Reference No:	2023/62/92484/E
Site Address:	73, Westfield Lane, Scholes, Cleckheaton, BD19 6DR
Description:	Erection of two storey rear extension
Recommending Officer:	Elenya Jackson

DECISION – CONDITONAL FULL PERMISSION

OFFICER REPORT

PROPOSED

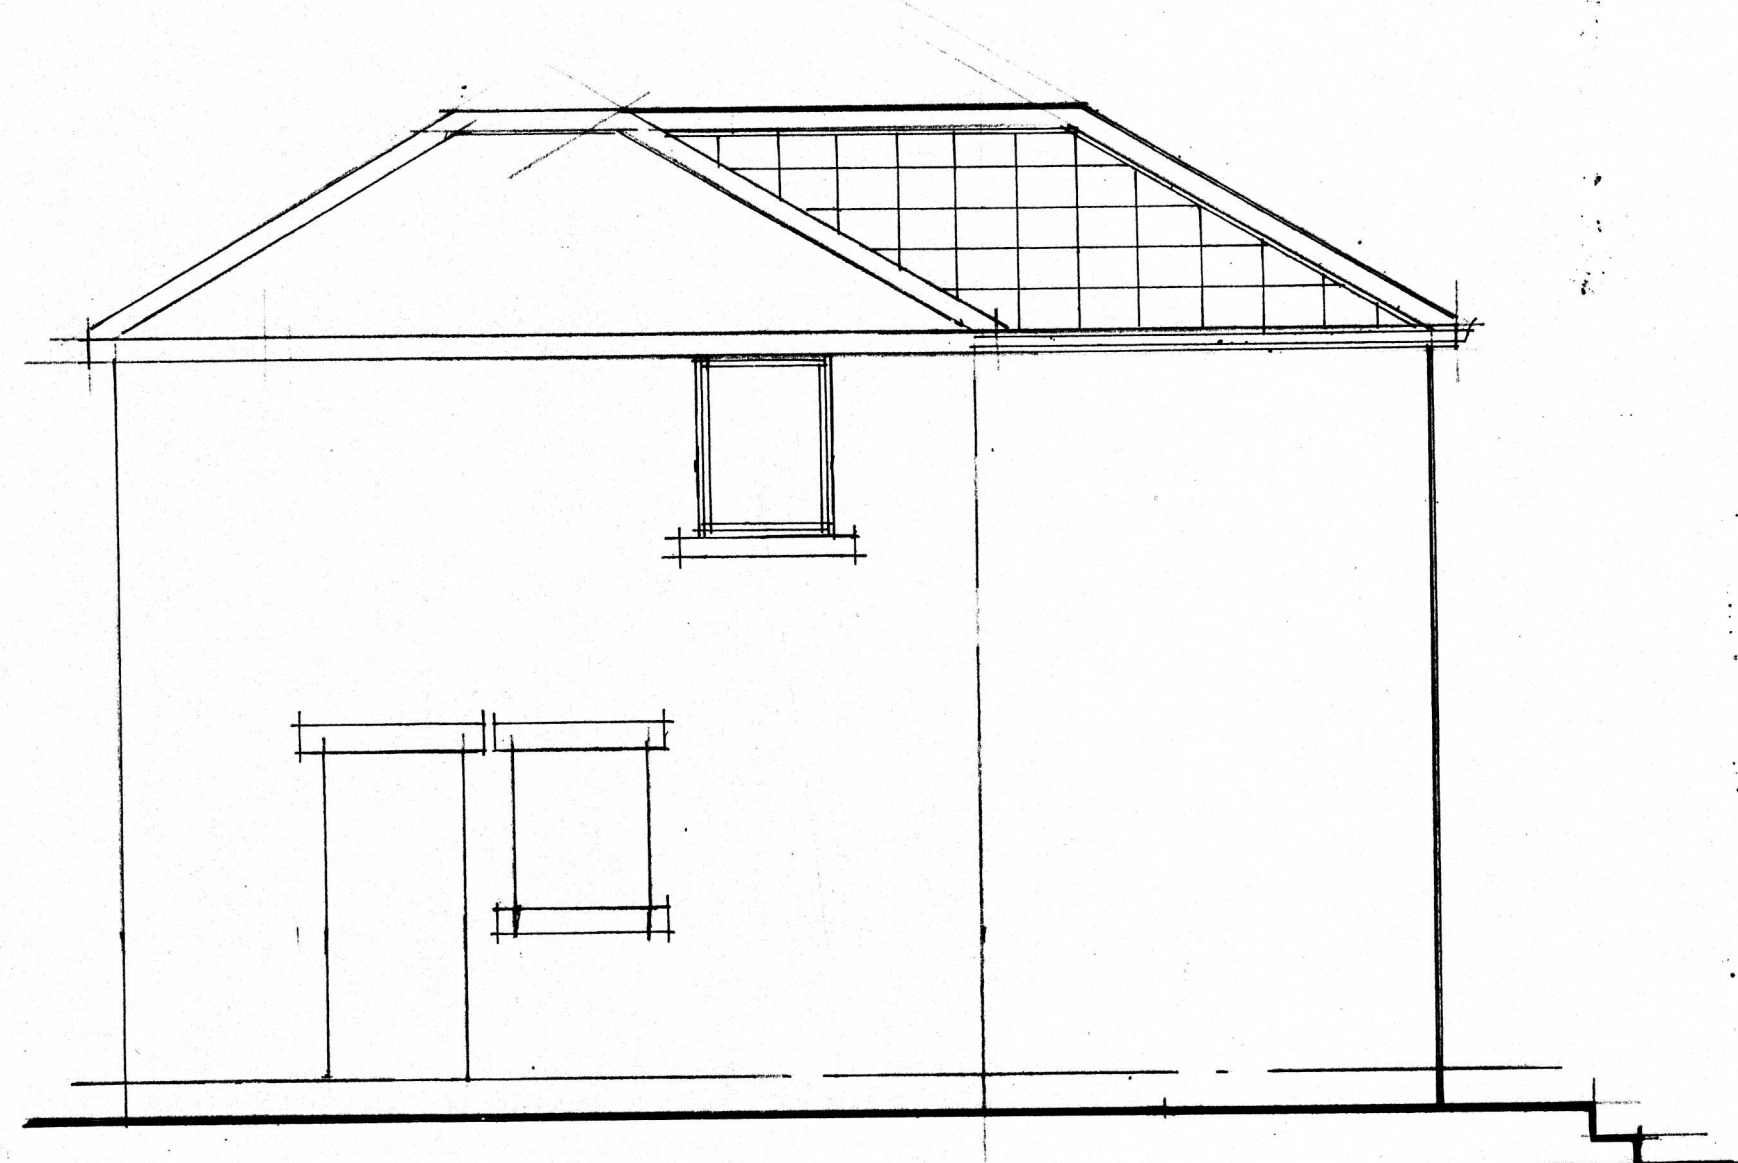
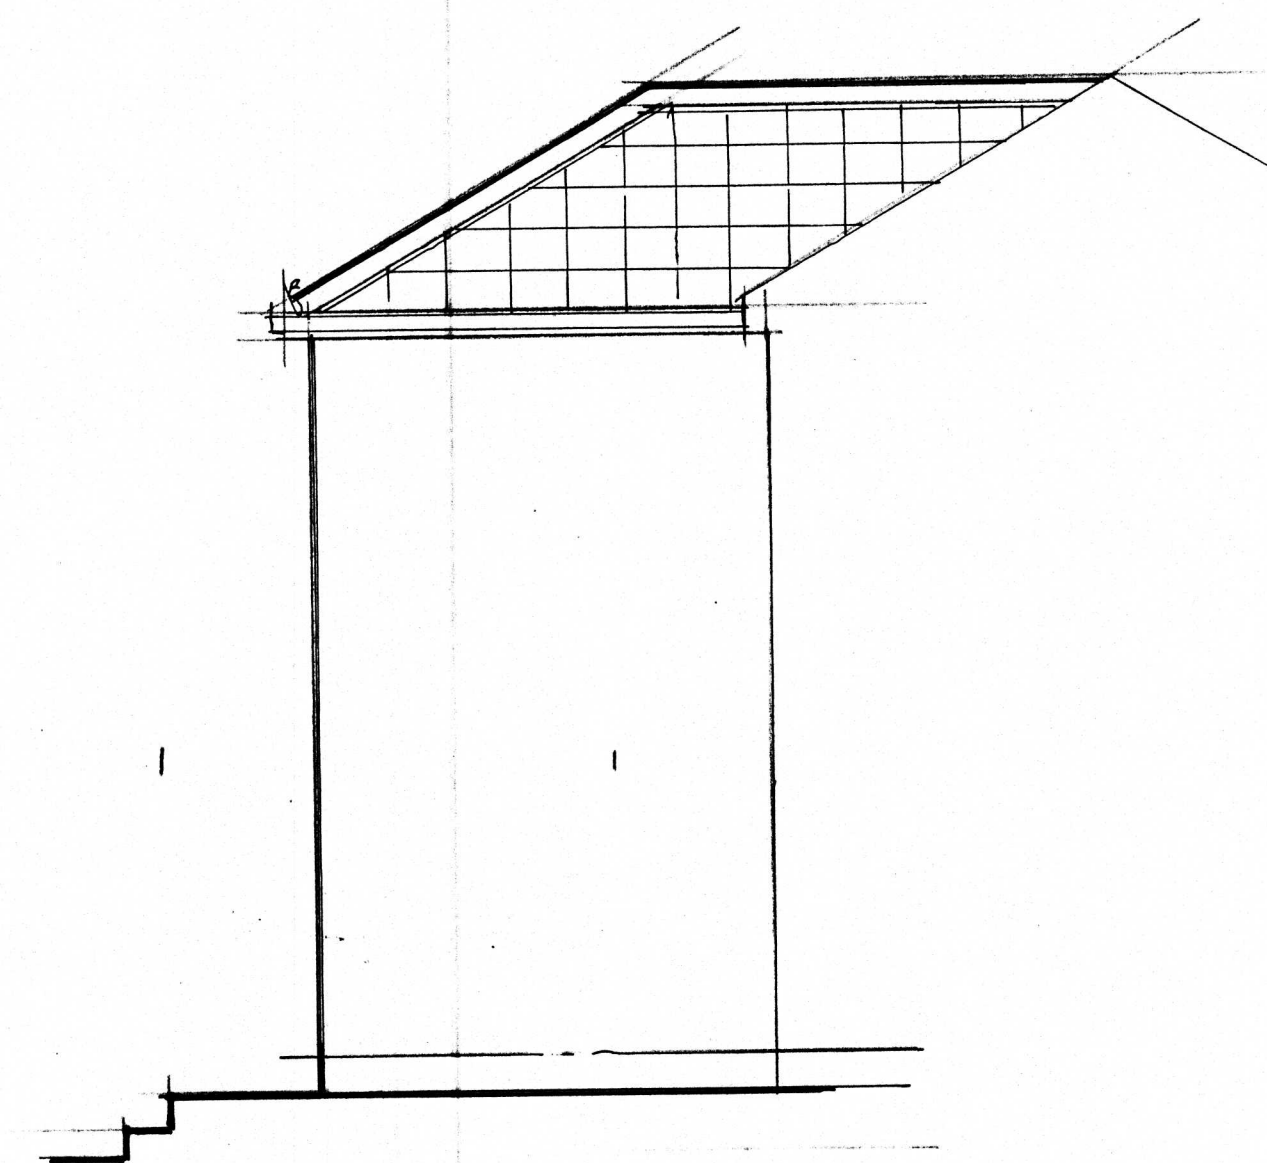
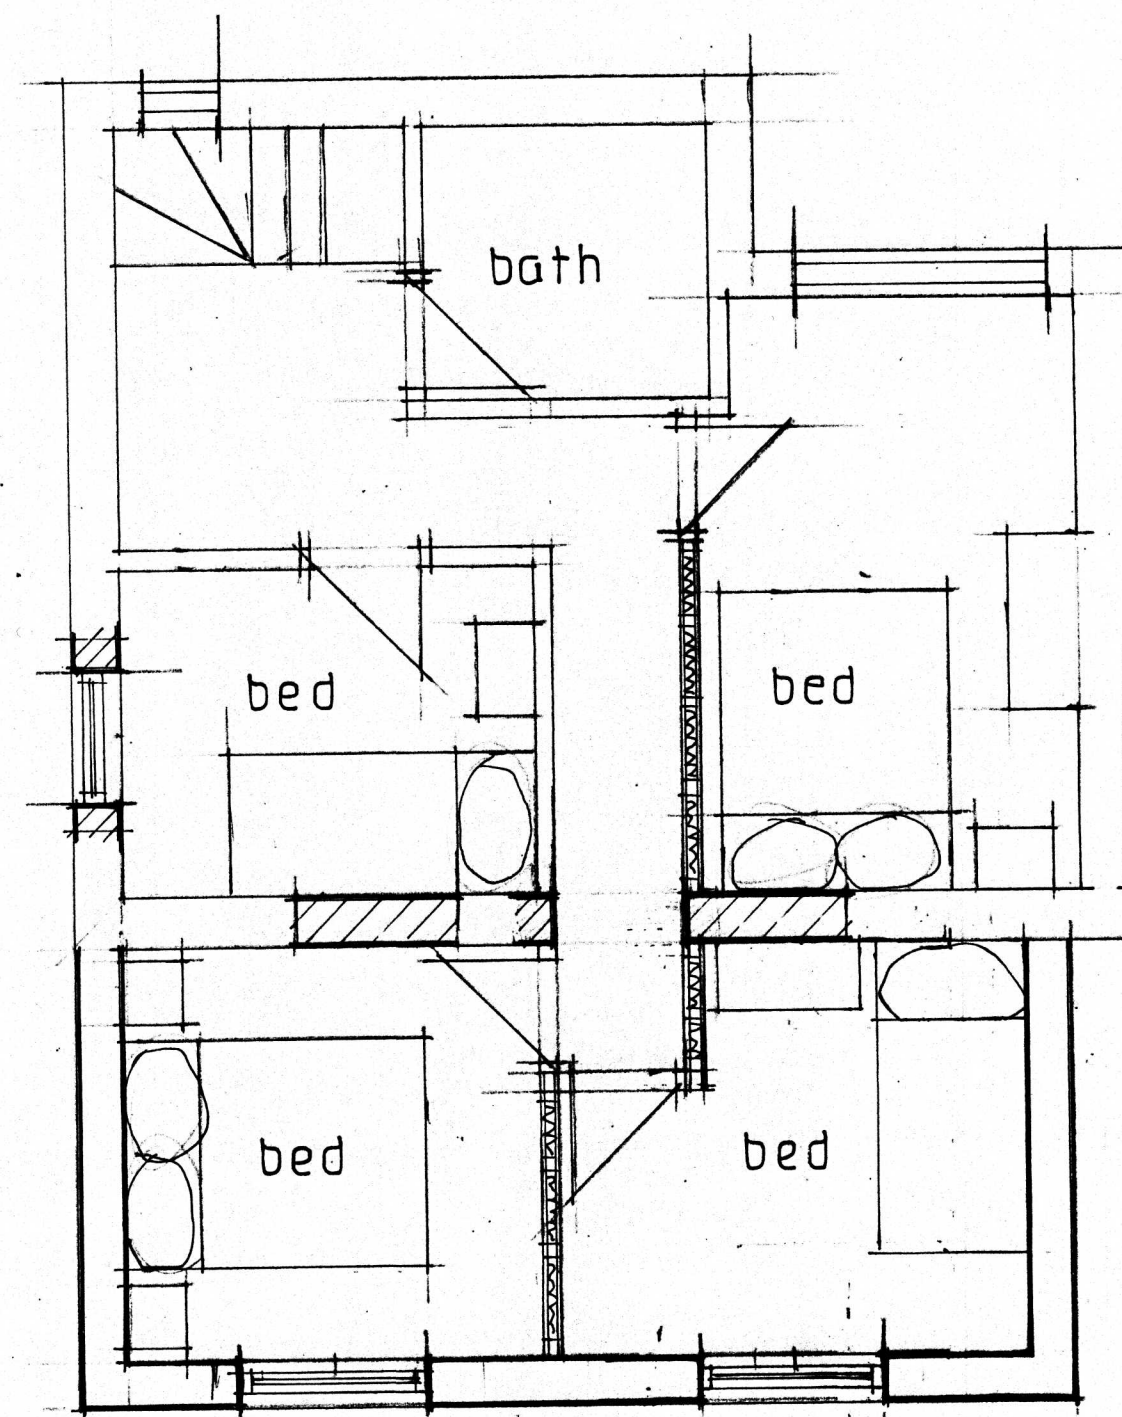
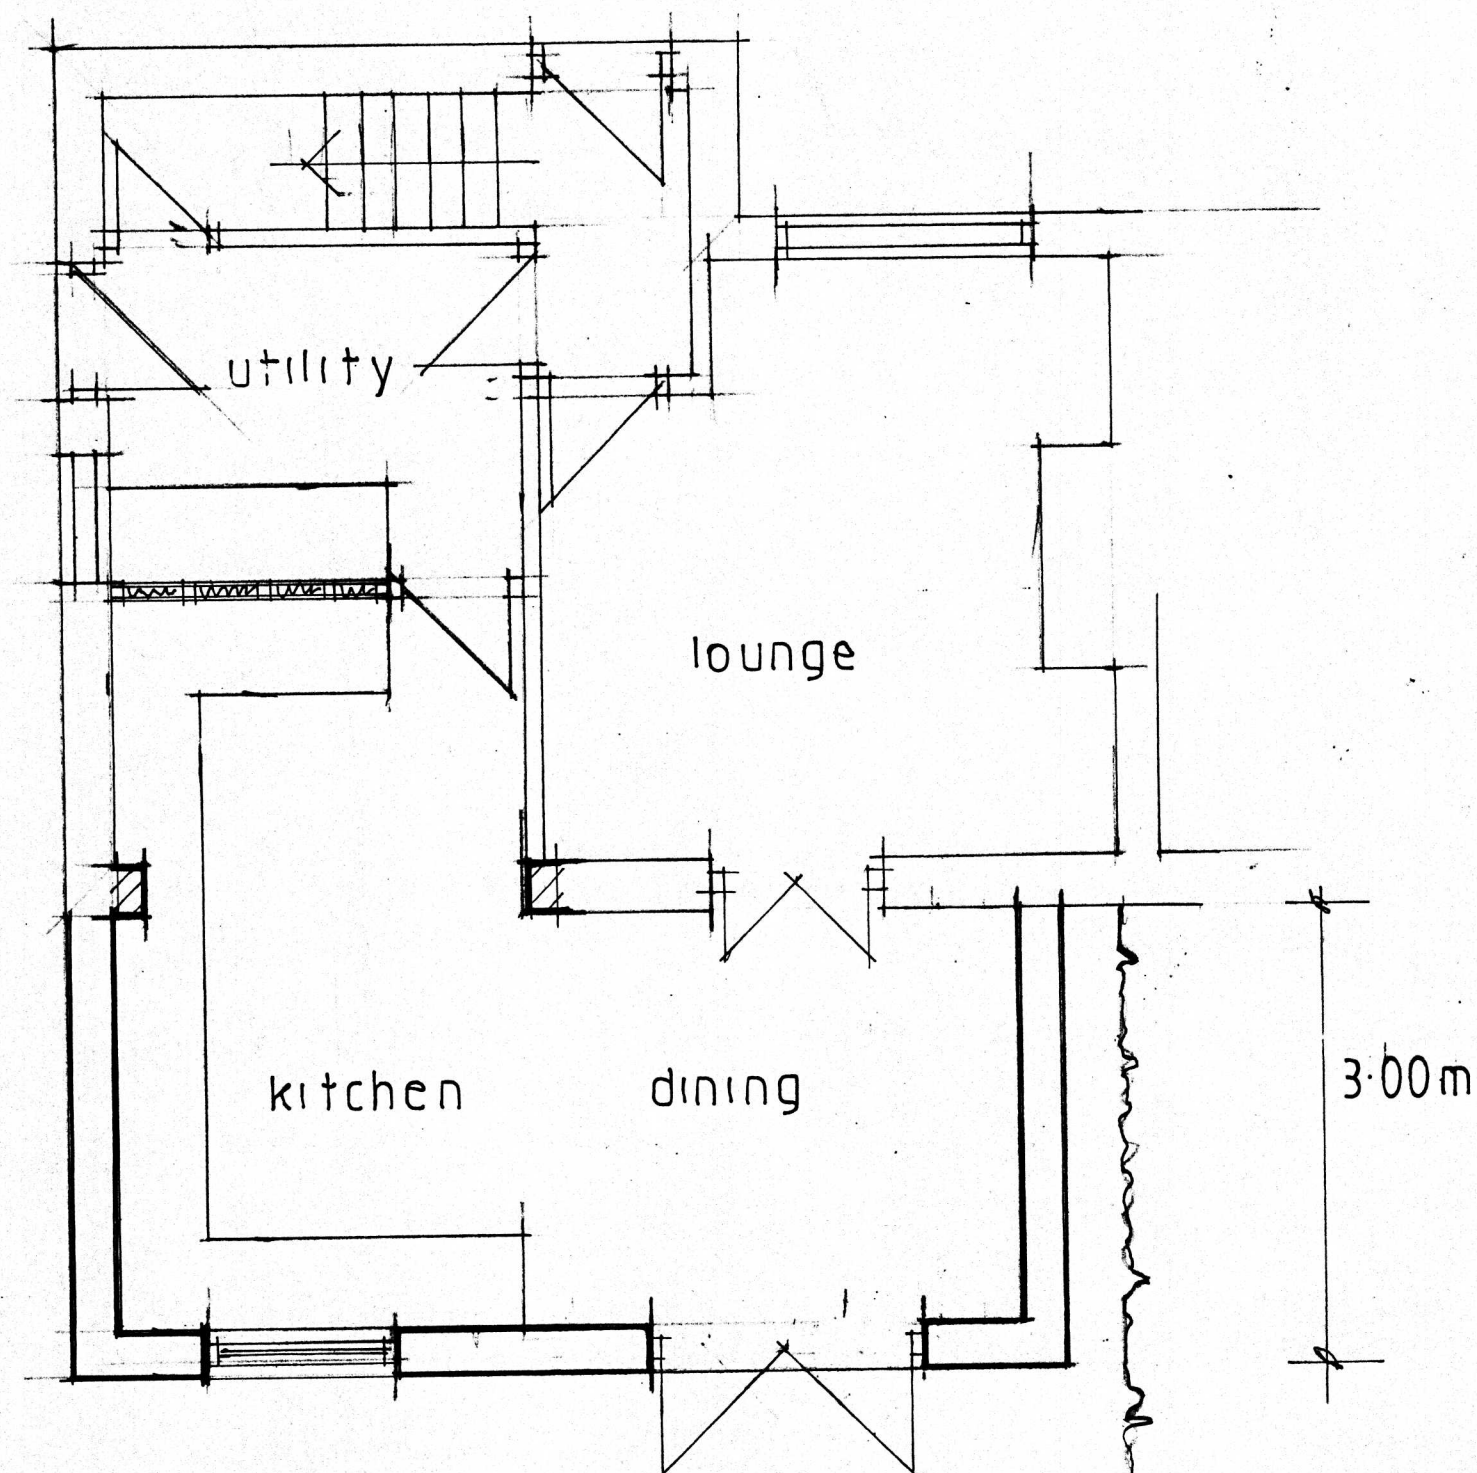
The proposed two storey extension would extend a maximum of 3m beyond the rear elevation of the dwelling and would be set away from the shared boundary between neighbouring dwellings. It is acknowledged that the proposal would be half a meter from the shared boundary with the eastern neighbour; however, it is considered that due to the open nature of the site, the extension would not appear cramped in its plot as a result of this reduced separation distance.

Overlooking: the proposal would not feature any side facing windows

Overshadowing/loss of light/overbearing: the two storey extension would be situated 0.5m away from the shared boundary between the dwellings. The windows for both properties are currently situated 1.5m away from the shared boundary between the dwelling. The proposal would fall within the vertical 45 degree visibility splay of the ground floor rear facing windows of no.71 but not the horizontal and therefore no significant issues would arise regarding overshadowing/loss of light/overbearing.

Overlooking: The proposal would feature one side facing window in the host property for a bedroom. This would be in line with the host property and therefore no significant issues would arise regarding overlooking.

Overshadowing/loss of light/overbearing: the proposal would be set away from the shared boundary between the dwellings and therefore no significant issues would arise regarding overshadowing/loss of light/overbearing.
